Re: Objection to the Proposed Tirawley Wind Farm Strategic Infrastructure

Re: Planning permission for the construction of Tirawley Windfarm consisting of 16 no. wind turbines, a permanent 110kV substation, 110kV underground cable and grid connection, and ancillary development in the townlands of Ballymurphy, Ballynaleck, Barnhill Lower & Upper, Barroe, Billoos, Carn, Carrickanass, Carrowmore, Castlелacken Demesne, and other townlands in County Mayo.

Case Number: PAX16.324258

PUBLIC ROAD WIDENING - DETAIL

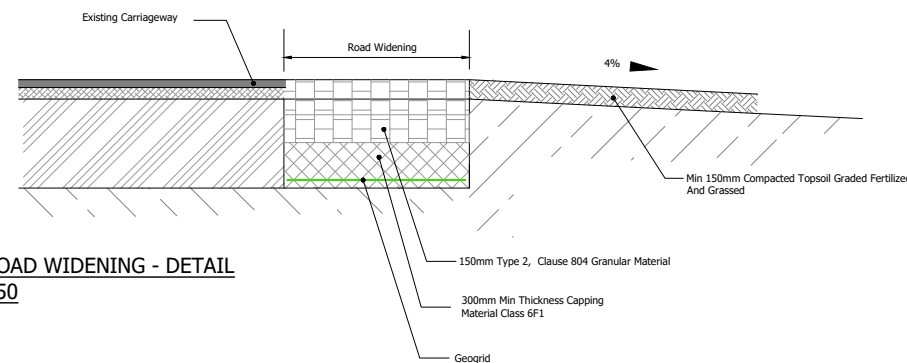
It seems from the site layout maps that the developer wants to take my boundary fences for road widening along the L5179-23, including outside my yard gate. I have not been notified of this or been asked for permission. If I had been asked I would not have given permission. On the verge of the road outside my yard in Barnhill there is Japanese Knotweed growing. It cannot be disturbed by order of Mayo County Council because they are keeping it under control by spraying it. This has stopped it from spreading but road widening works proposed by the developer will undo all this progress.

Figure 12.3 ZTV indicating the cumulative theoretical visibility of the proposed Tirawley Wind Farm in combination with all other wind farms in the study area

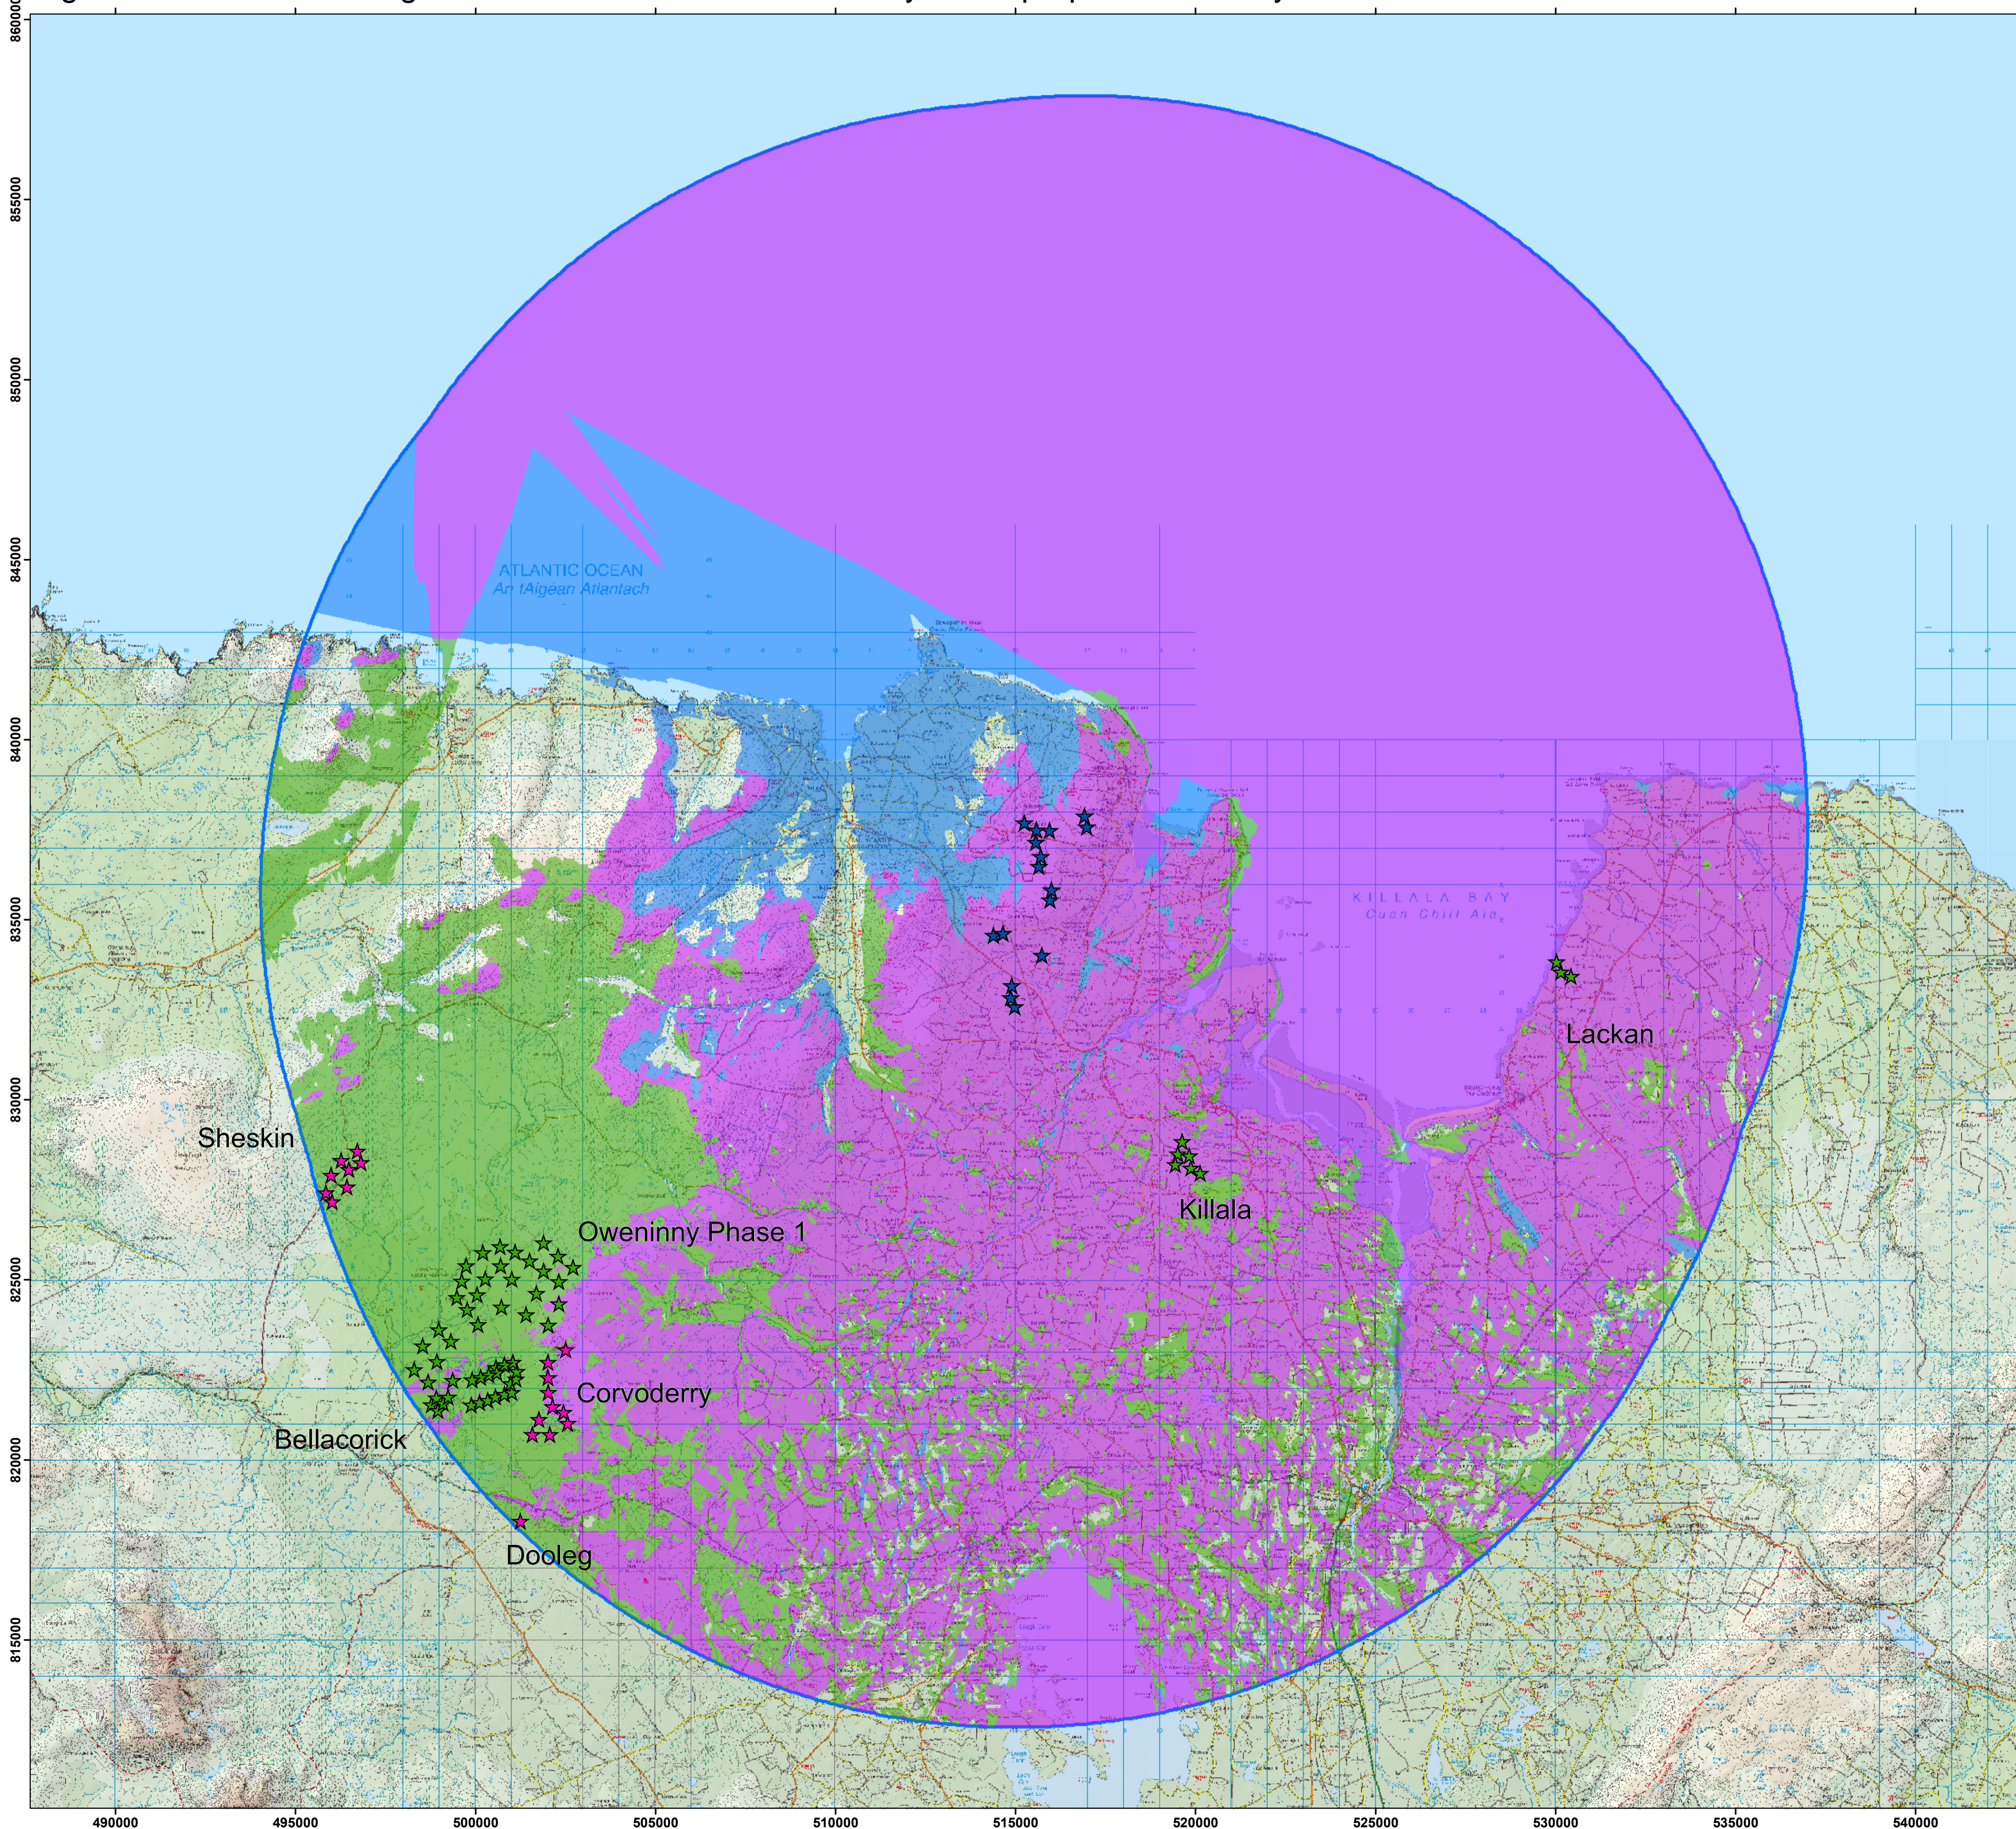
I also wish to adopt and support the detailed submission made by the Lacken Ballycastle Landscape Protection Group in relation to the proposed Tirawley windfarm development (PAX16.324258). In particular, I endorse the concerns raised regarding cumulative wind farm development across North Mayo, impacts on the Céide Fields cultural landscape, effects on
